From: Martyn White <Martyn.White@arun.gov.uk>
Sent: 31 January 2020 17:18
To: Zac Denton <Zac.Denton@arun.gov.uk>
Cc: Planning.Responses <Planning.Responses@arun.gov.uk>
Subject: AB/135/19/HH & AB/136/19/L

AB/135/19/HH & AB/136/19/L

Proposed internal and external alterations including replacement of selected windows and doors and new ground floor terrace to provide more flexible family living accommodation and a lower ground floor annex.

Proposed External Doors - 2

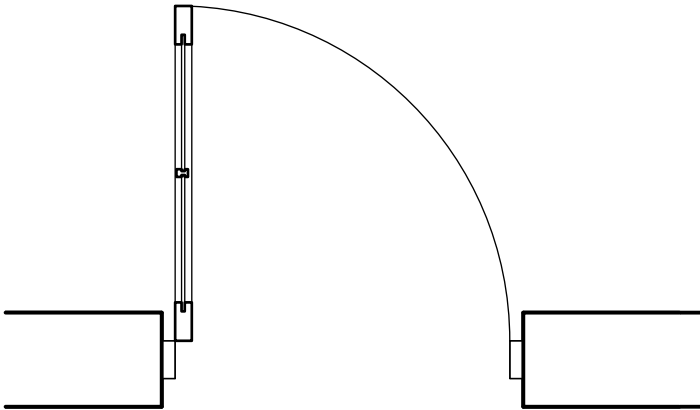
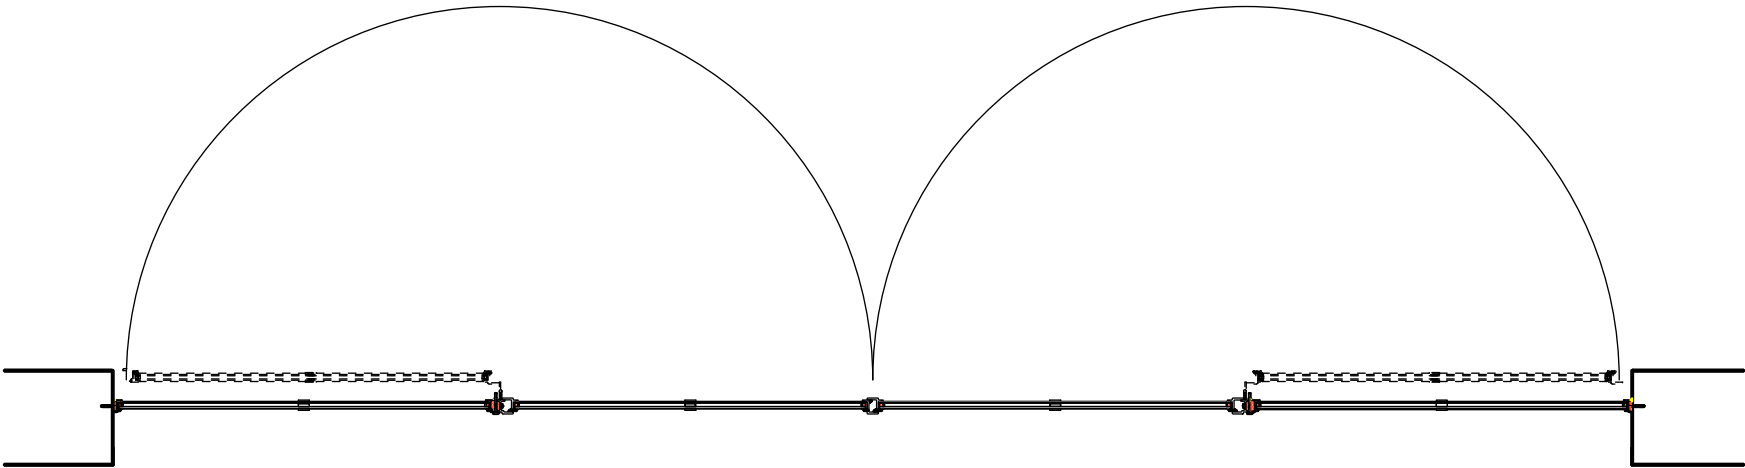
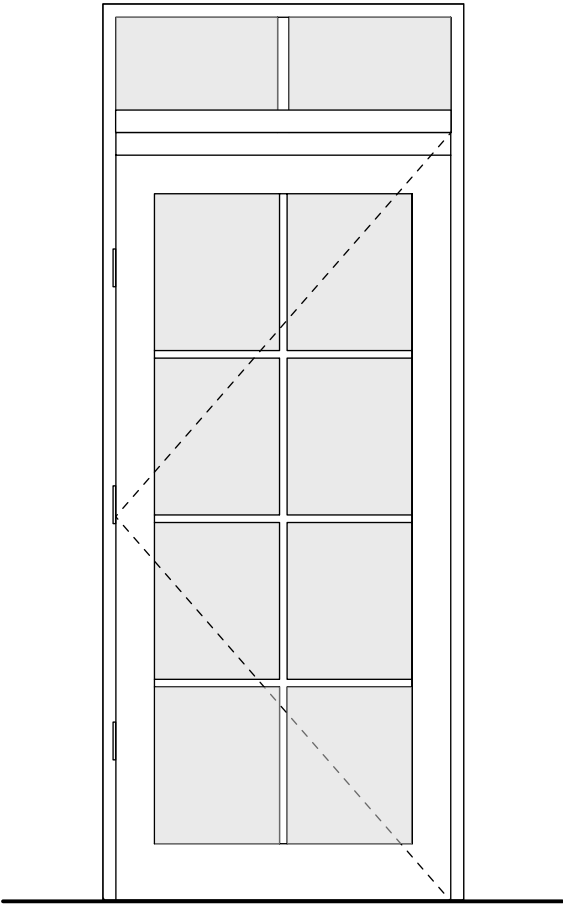
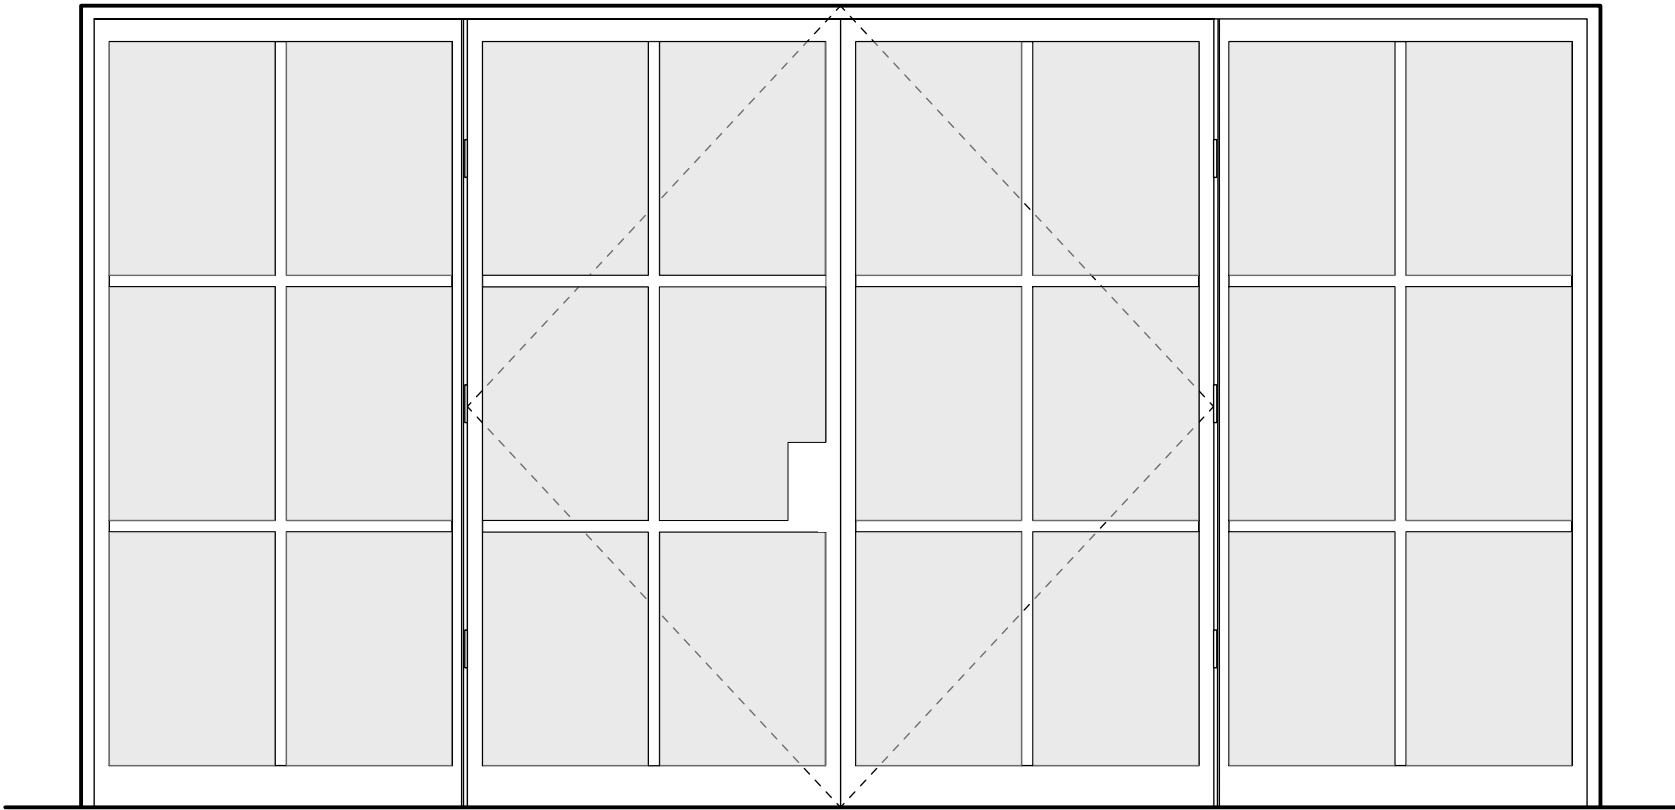
Likewise, it is not clear what glazing systems are proposed for the new windows. Please can this be confirmed?

Proposed Internal Doors

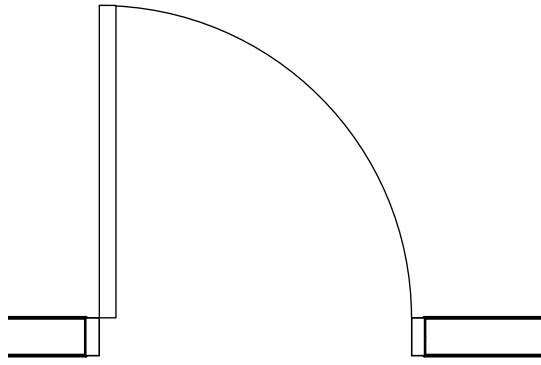
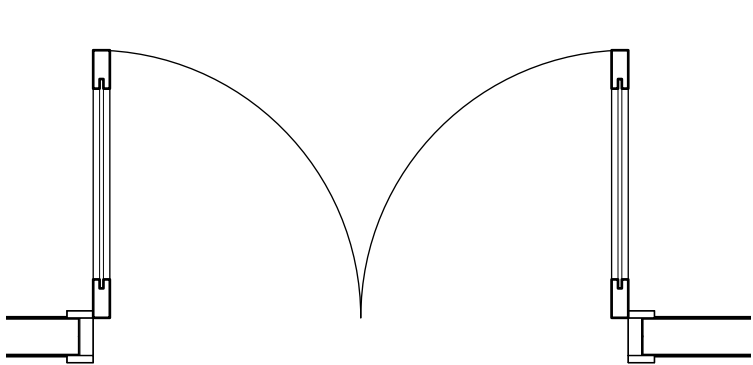
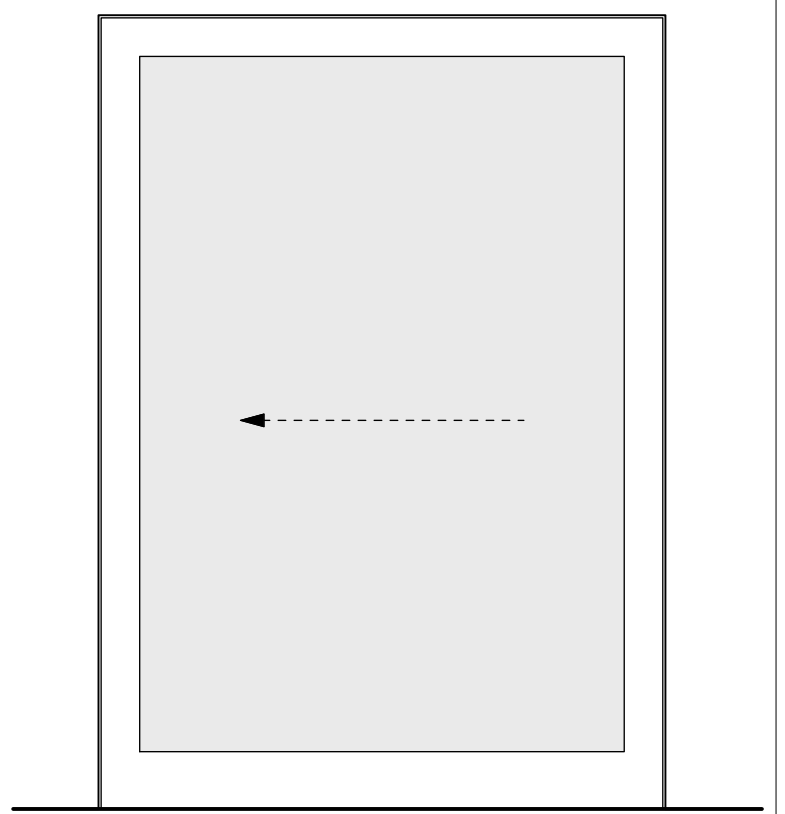
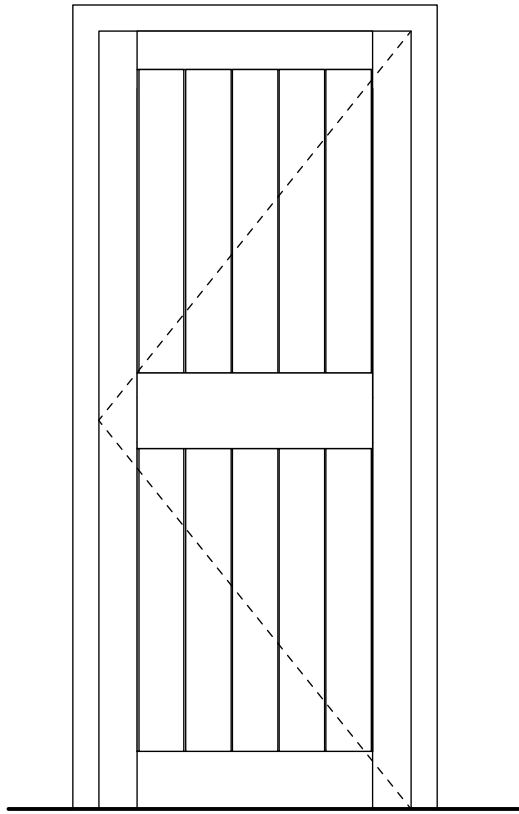
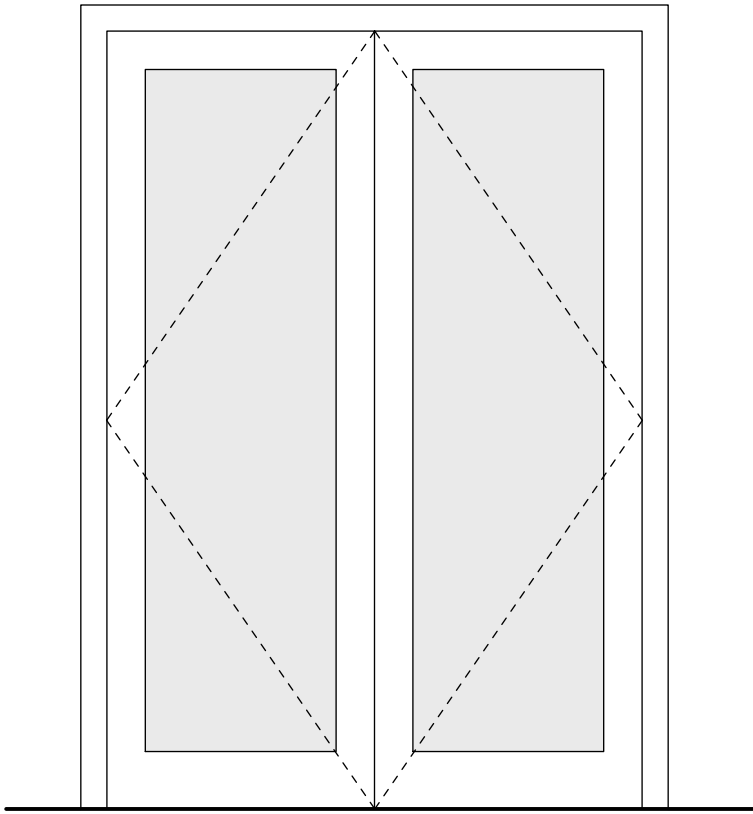
Details of the internal doors have been provided as part of the proposals; however, it is not clear why such a style has been chosen for all of the doors when they do not seem to reflect the character or Age of the building? At present they seem to be appropriate to a cottage, as opposed to a more genteel looking home, and are problematic.
